Your ref: SSD-69799460
Our ref: DOC25/408266-9

Subject: Tilbuster 2 Solar Farm EIS (SSD-69799460)

ATTACHMENT C Detailed comments for Tilbuster 2 Solar Farm Environmental Impact Statement (SSD-69799460)

Figure 1.2 shows the indicative layout for the proposal, including the location of solar PV panels, associated infrastructure and internal access roads.

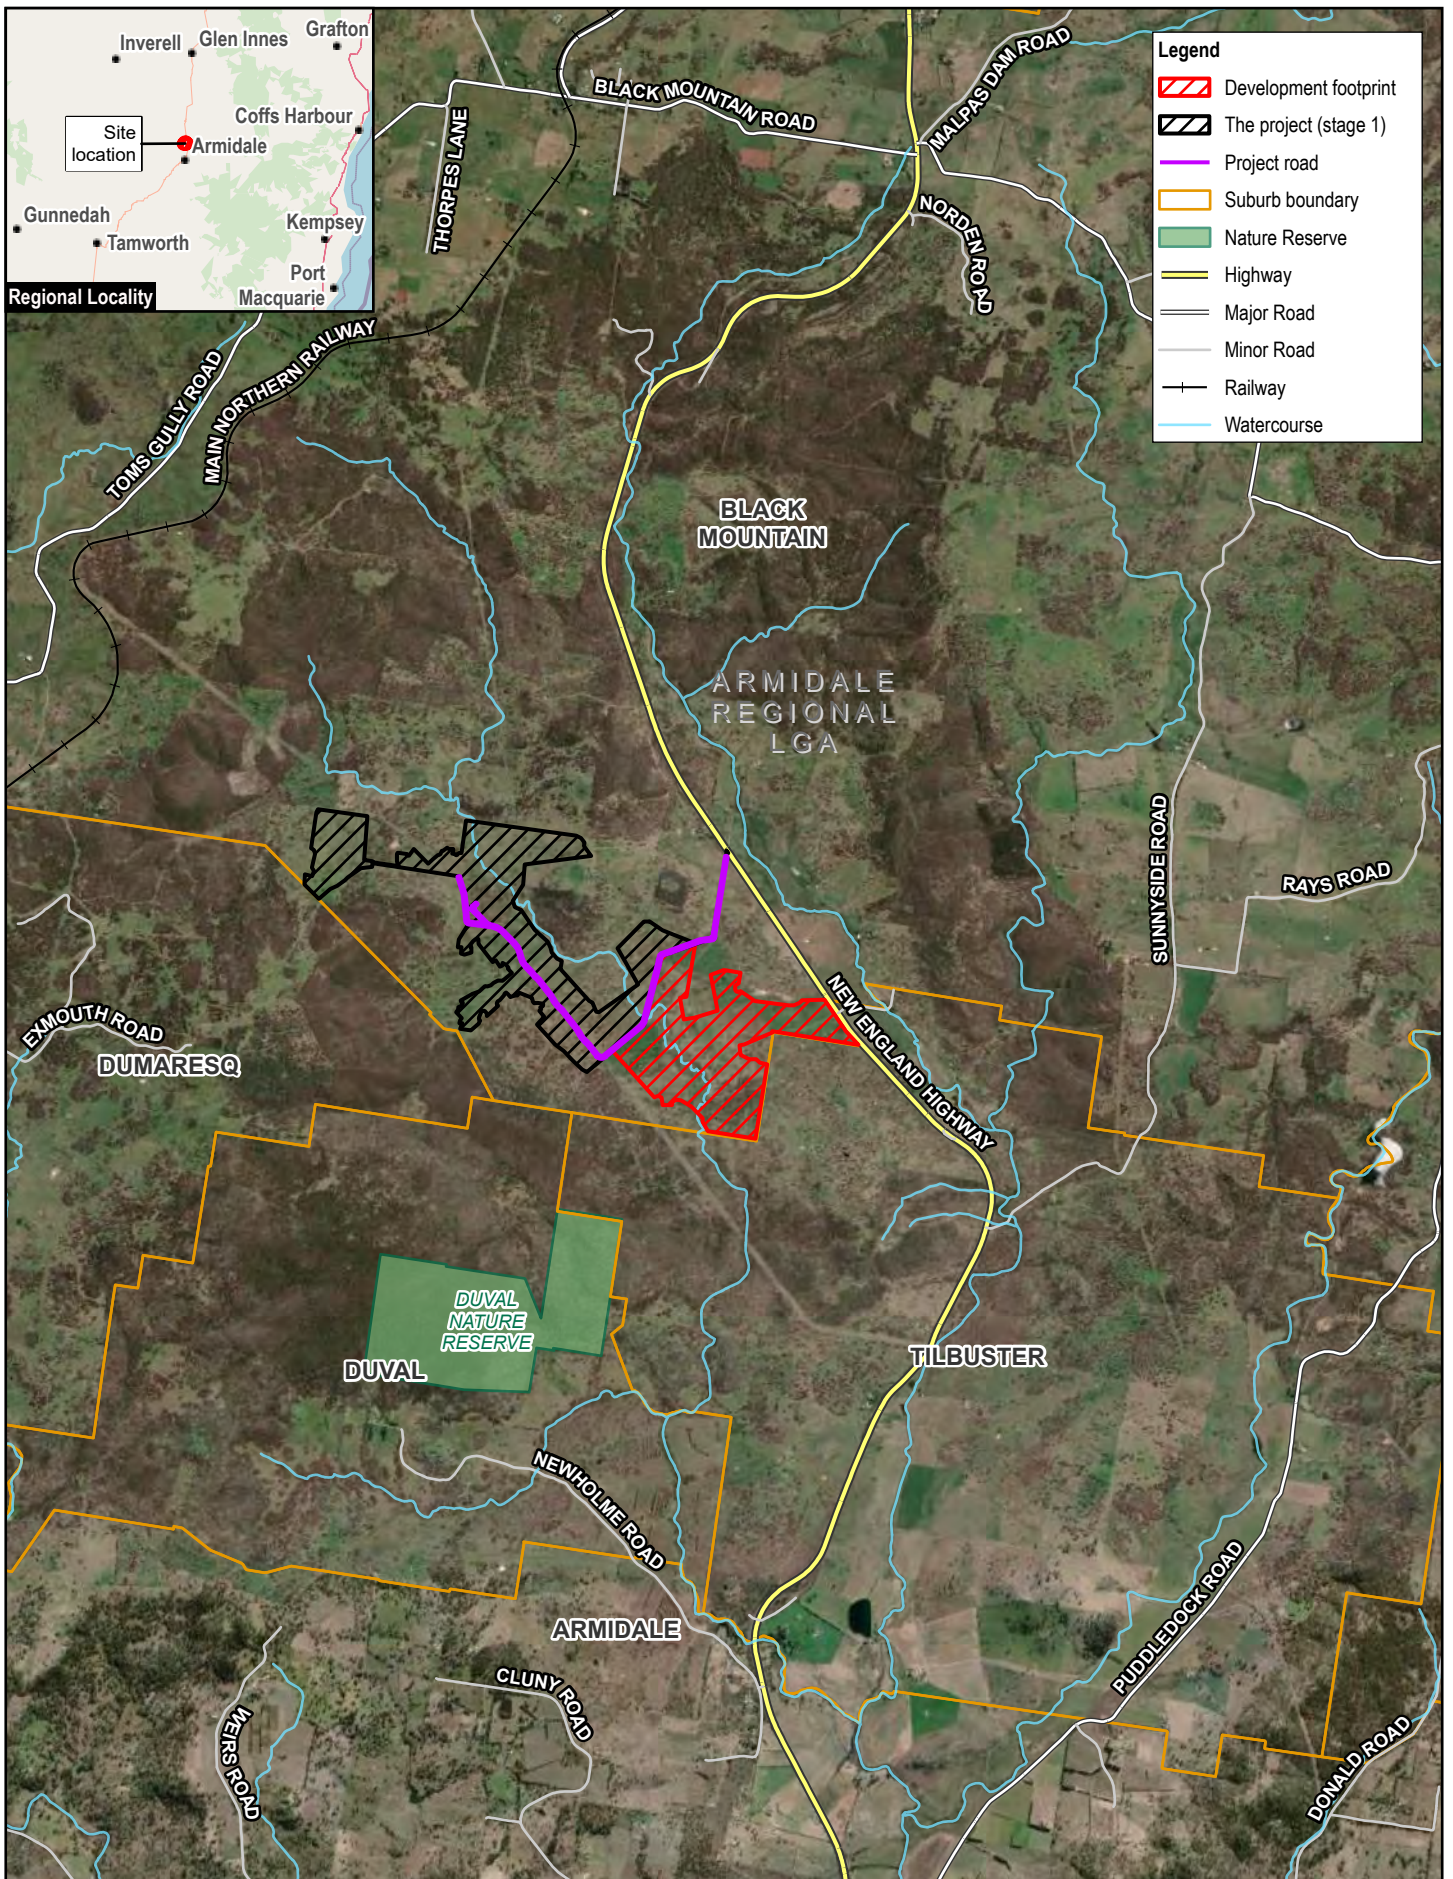
The proposed development footprint shown in Figure 1 of the BDAR does not include all sections of the proposed perimeter fence illustrated in the master plan contained in Appendix 2 of the BDAR (refer to Figure 2 below). The perimeter fence will result in direct impact for construction and long-term indirect impact on retained ecological communities within the fenced area by restricting access to some fauna species required for propagule exchange and maintenance of vegetation structure (e.g. macropods).

Figure 2: Sections of proposed security fencing not included in the development footprint assessed in the BDAR (broken red lines within the red polygons).

If habitat connectivity is not considered in the design and location of perimeter fencing, then long-term indirect impacts may arise on the floristic composition and structure of remnant vegetation retained within the development site (refer to Figure 6 below) by the fencing restricting access for

Figure 6: The main areas of native vegetation (in red polygons) retained within the development site, which would be isolated by the location of proposed perimeter fencing.

These indirect impacts of perimeter fencing can be reduced by realigning the fence as close to the solar arrays and internal roads as possible to minimise isolation of retained native vegetation and maintain fauna movement along the Duval Creek riparian zone (refer to Figure 7 below).

Figure 7: Indicative re-alignment of perimeter fencing (green lines) closer to the solar arrays and internal roads to minimise isolation of retained remnants of native vegetation.

10. Proposed perimeter fencing be placed as close as possible to the solar arrays and internal roads to minimise isolation of retained native vegetation and optimise potential for fauna movement along the Duval Creek riparian zone.
